Date: August 4, 2022  
Subject: Intake Screening Revisions  
Project: Jwa611– 6221 83<sup>rd</sup> PI SE  
2207-110

The following are issues and responses raised in the Customer Service Team screening and Building Division screening dated July 27, 2022.

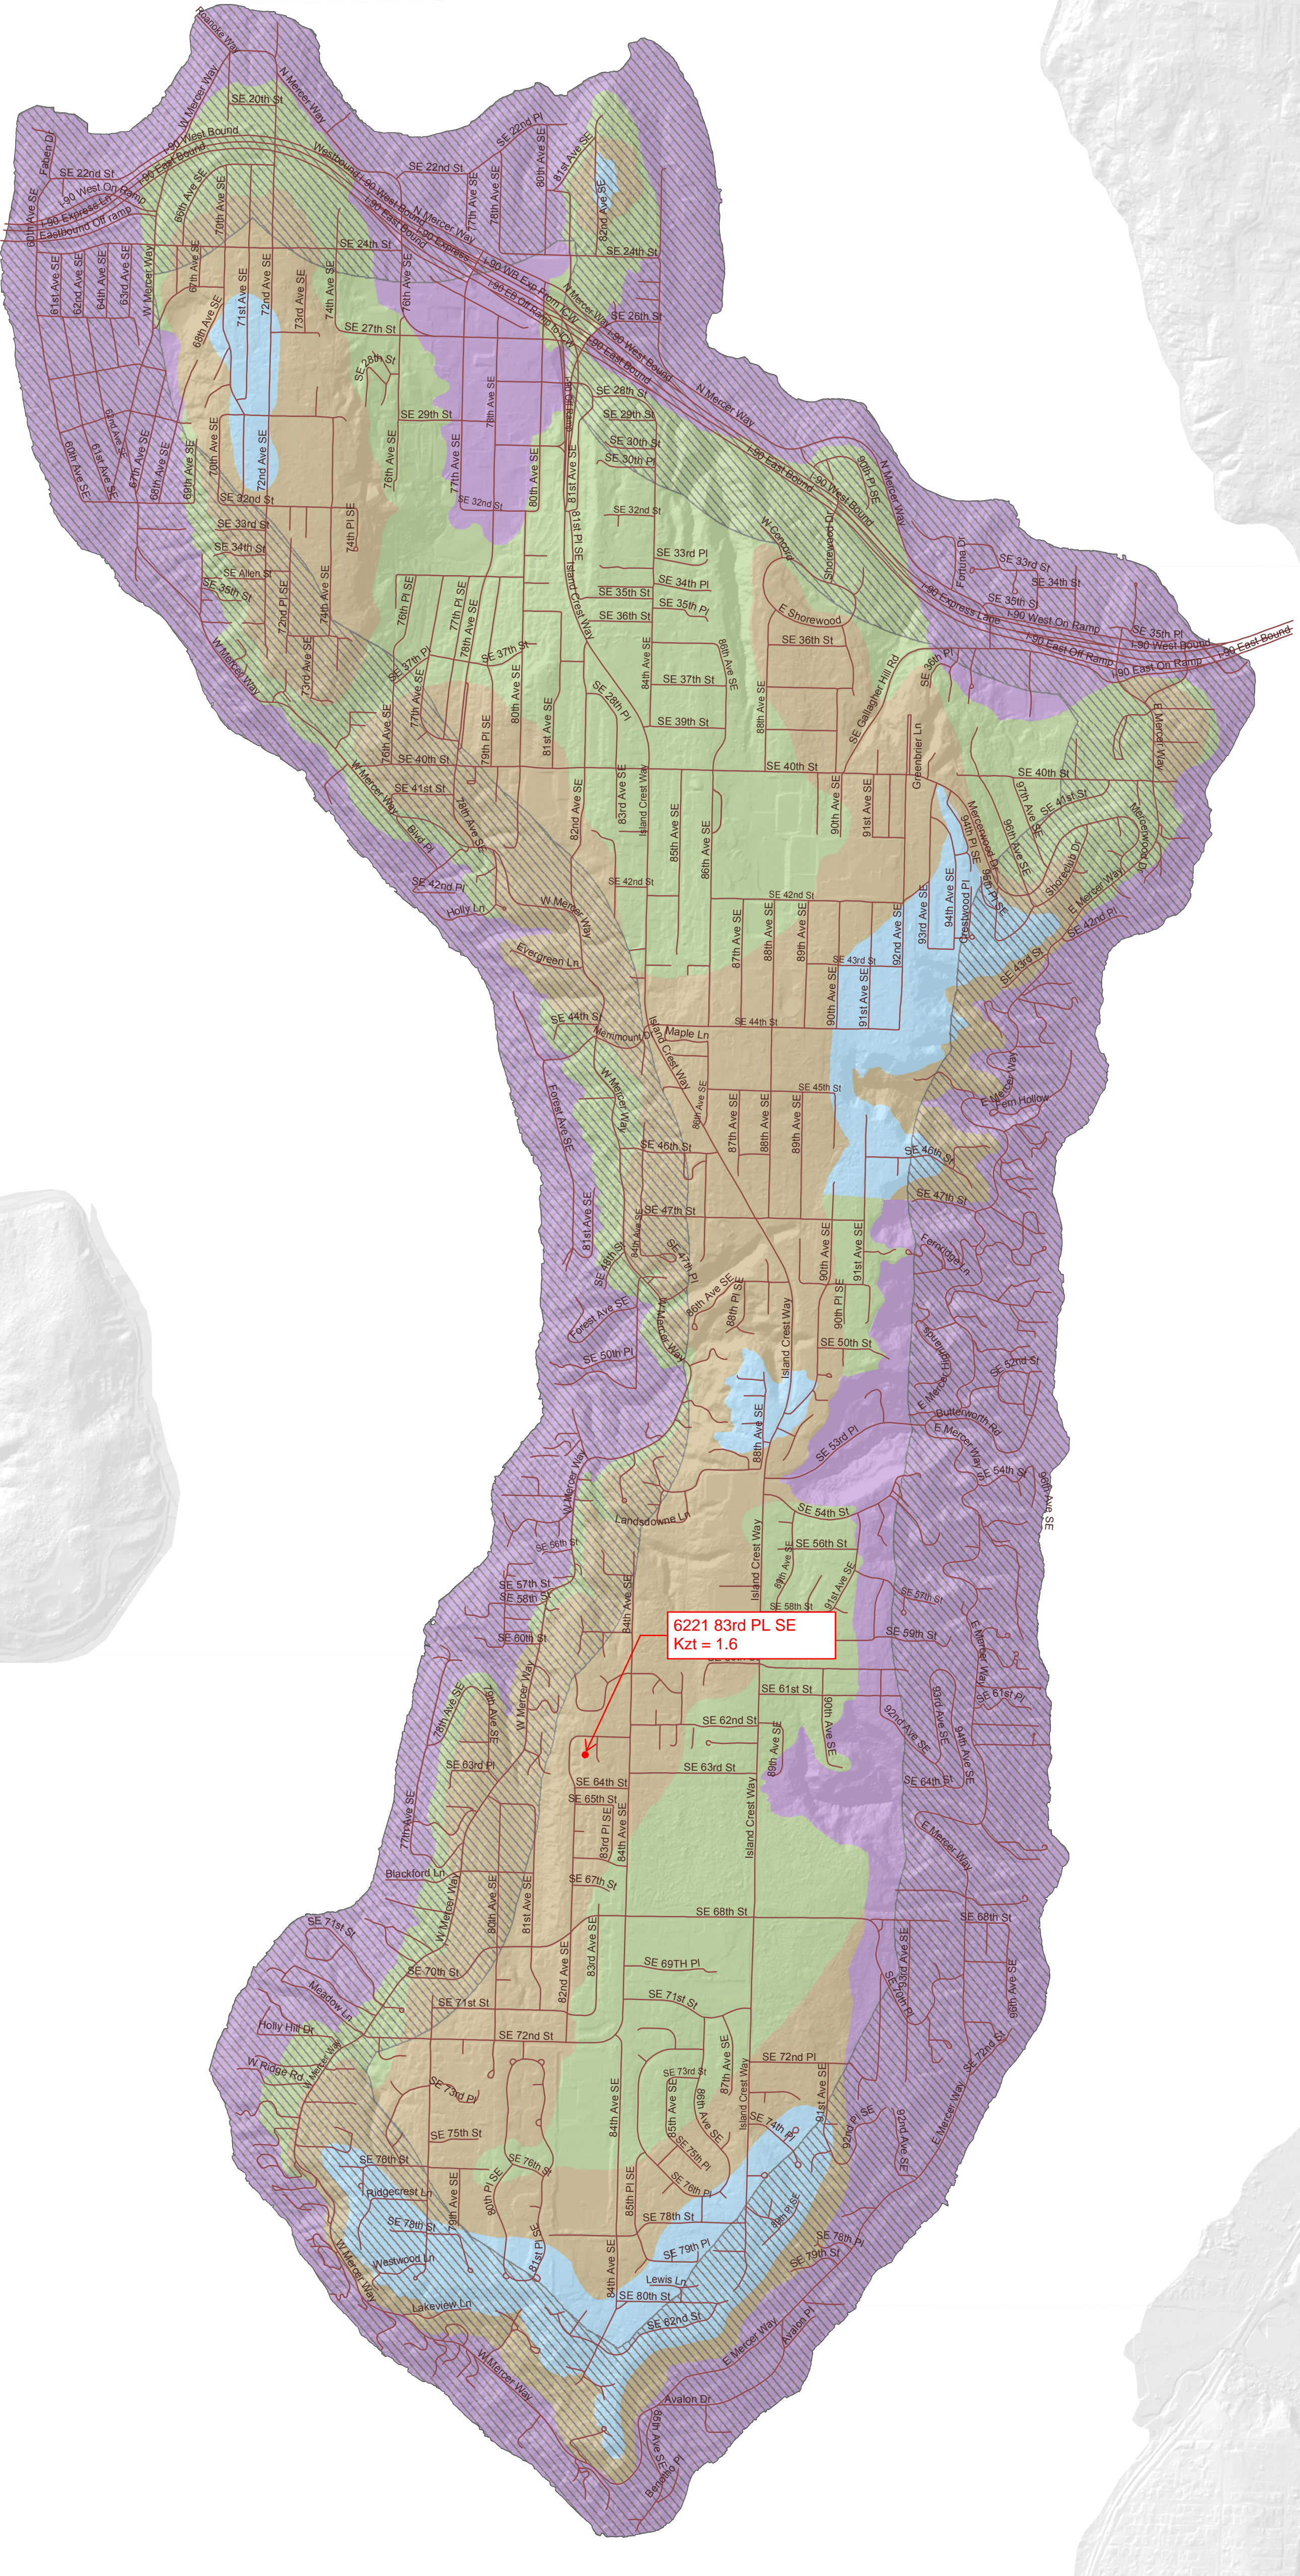
*“Please verify Kzt per city mapping, keyplans to facilitate review of gravity and lateral systems, and retaining wall calculations.”*

- Please refer to page 4 in the calculation package for the Kzt utilizing the City of Mercer Island Kzt map.
- Framing elements are called out per plan with “#\_\_” according to its corresponding calculations on pages V1-V4.
- Please refer to detail 4/S4.0 for the shearwall schedule and details 1 and 2/S4.0 for typical shearwall construction. Shearwalls are indicated per plan with “SW\_”, which denotes the shearwall type to be constructed according to the shearwall schedule. This shearwall notation is placed on the side of the wall to indicate which face shall be sheathed. All exterior walls are to be sheathed as “SW6” per plan note 4 on Sheet S2.4 and plan note 5 on Sheet 2.3 and plan note 7 on sheet S2.2. No changes to calculations or sheets have been made.
- Calculation package has been updated to include the retaining wall calcs.
